Our ref: NO/2012/103730/01-L01
Your ref: 3/2012/0292
Date: 07 June 2012

**EARTH BANKED SLURRY LAGOON
CLARK HOUSE,CHIPING, PRESTON, PR3 2GQ**

SECTION A-A

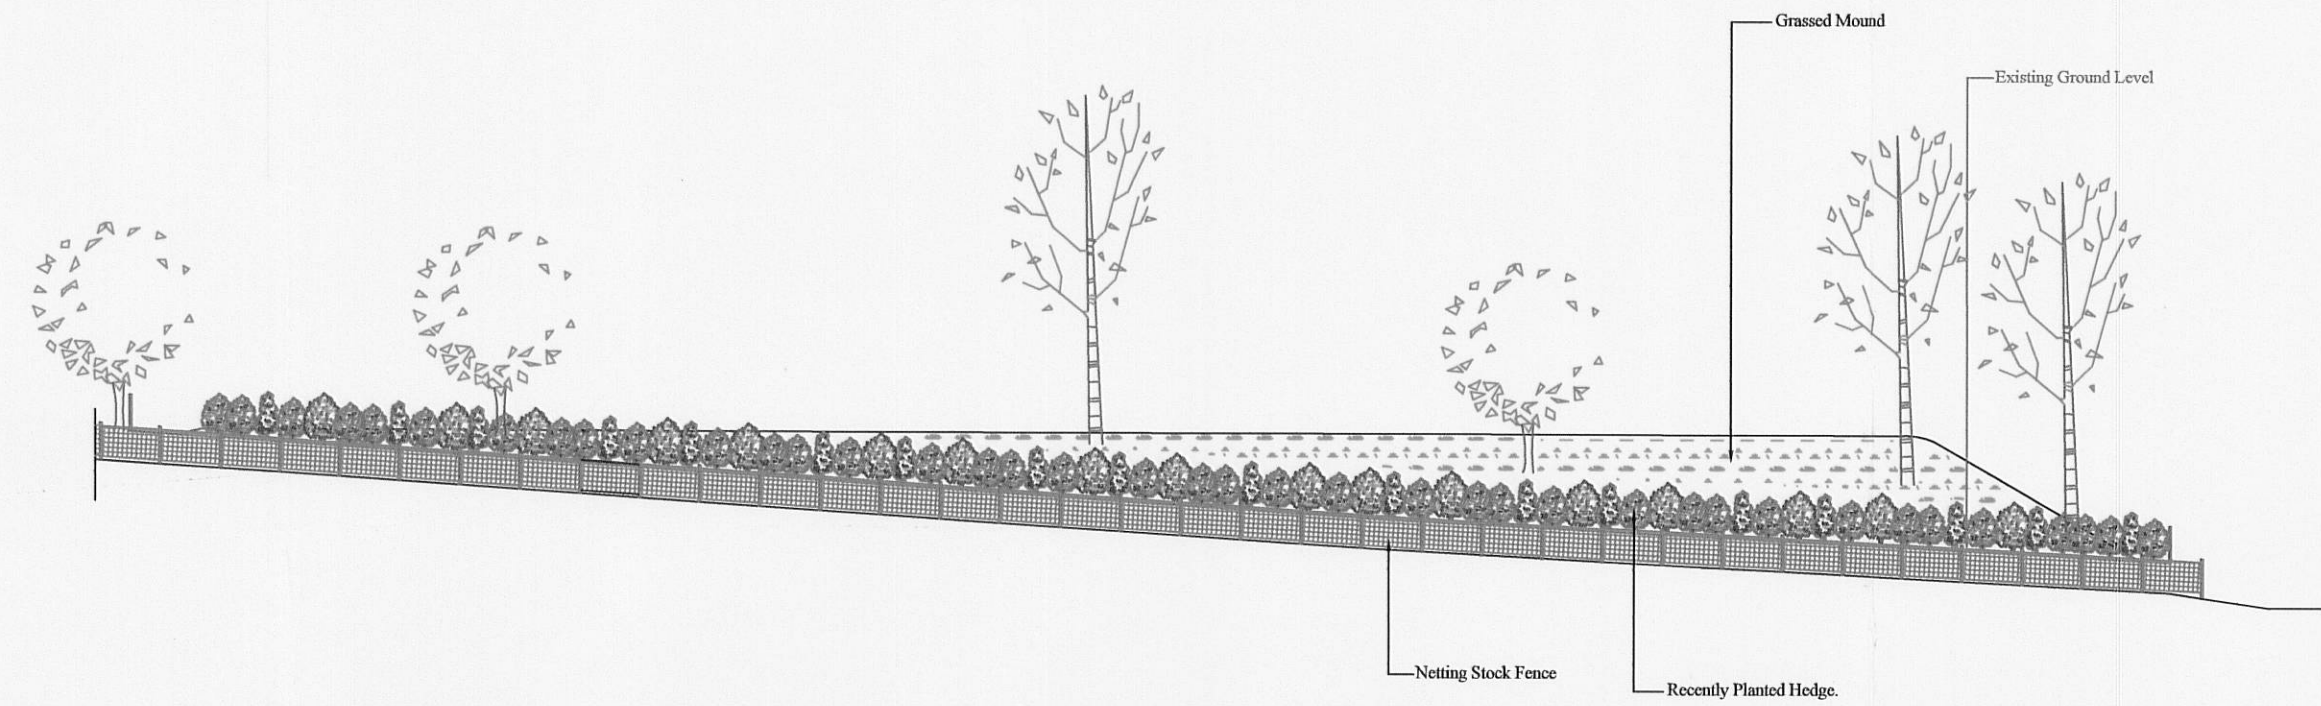
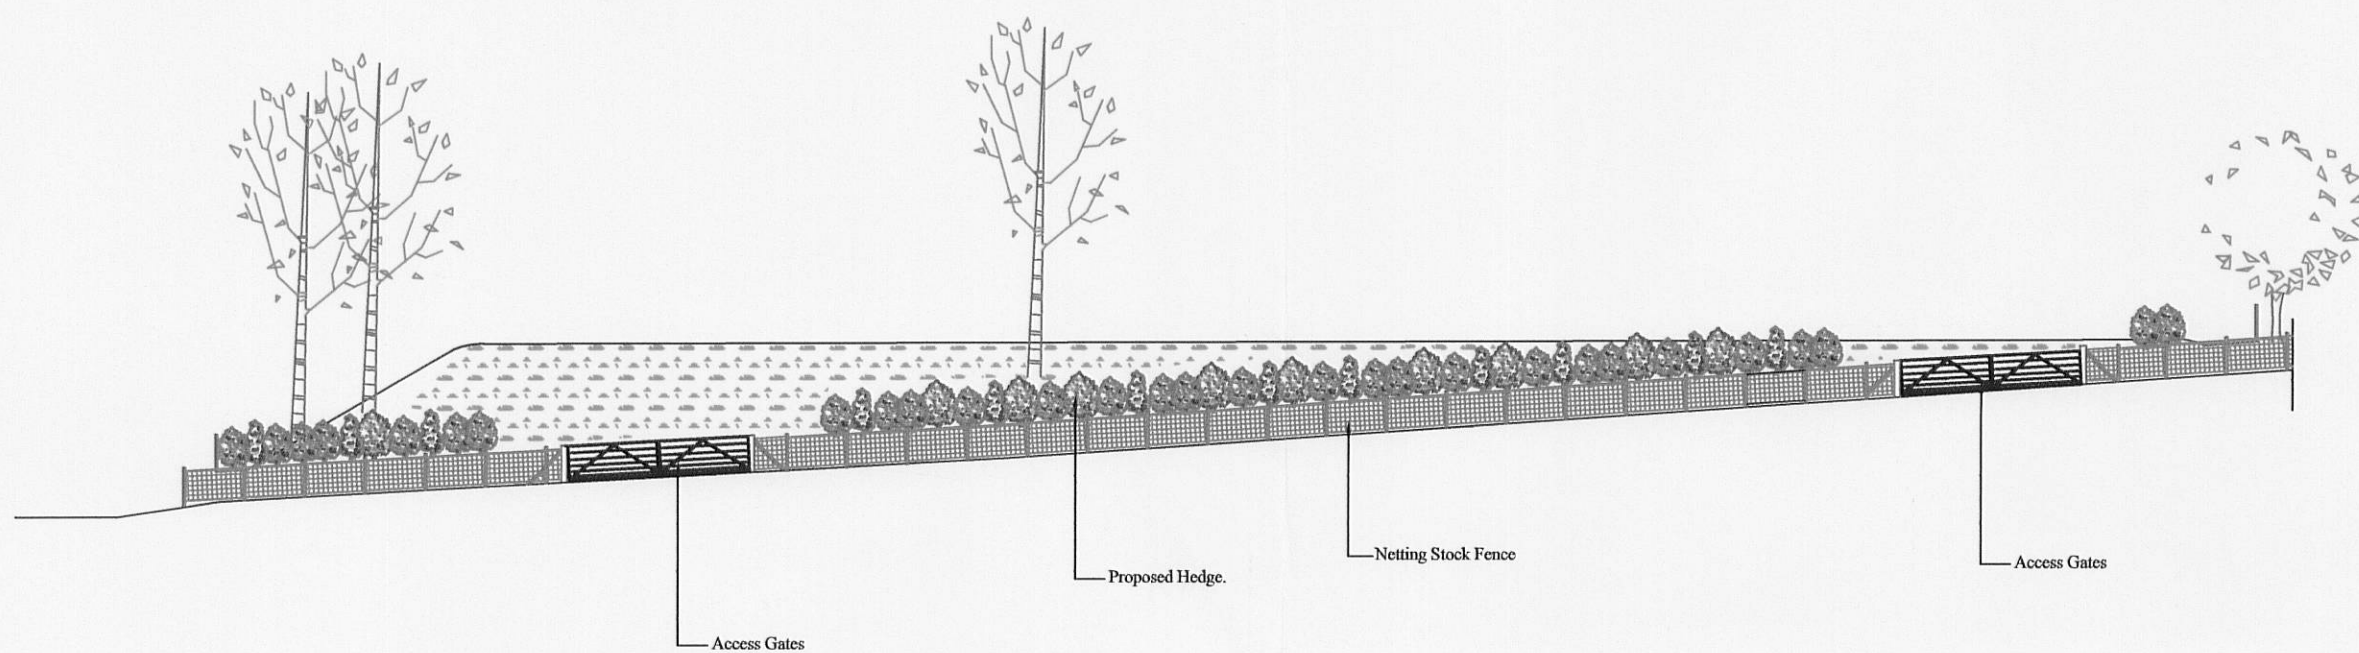
No development shall take place until a scheme has been submitted to and approved by the local planning authority which demonstrates there will be no resultant unacceptable risk to groundwater or unwanted impact on groundwater dependent features. The scheme should include:

A liner in the form of either a suitable sheet liner (incorporating leakage detection) or an imported clay liner at least 1 metre thick below the base of the lagoon and of permeability < 10⁻⁹ m/s

The proposed location at Springs House has a number of issues features which strongly suggest the presence of shallow groundwater
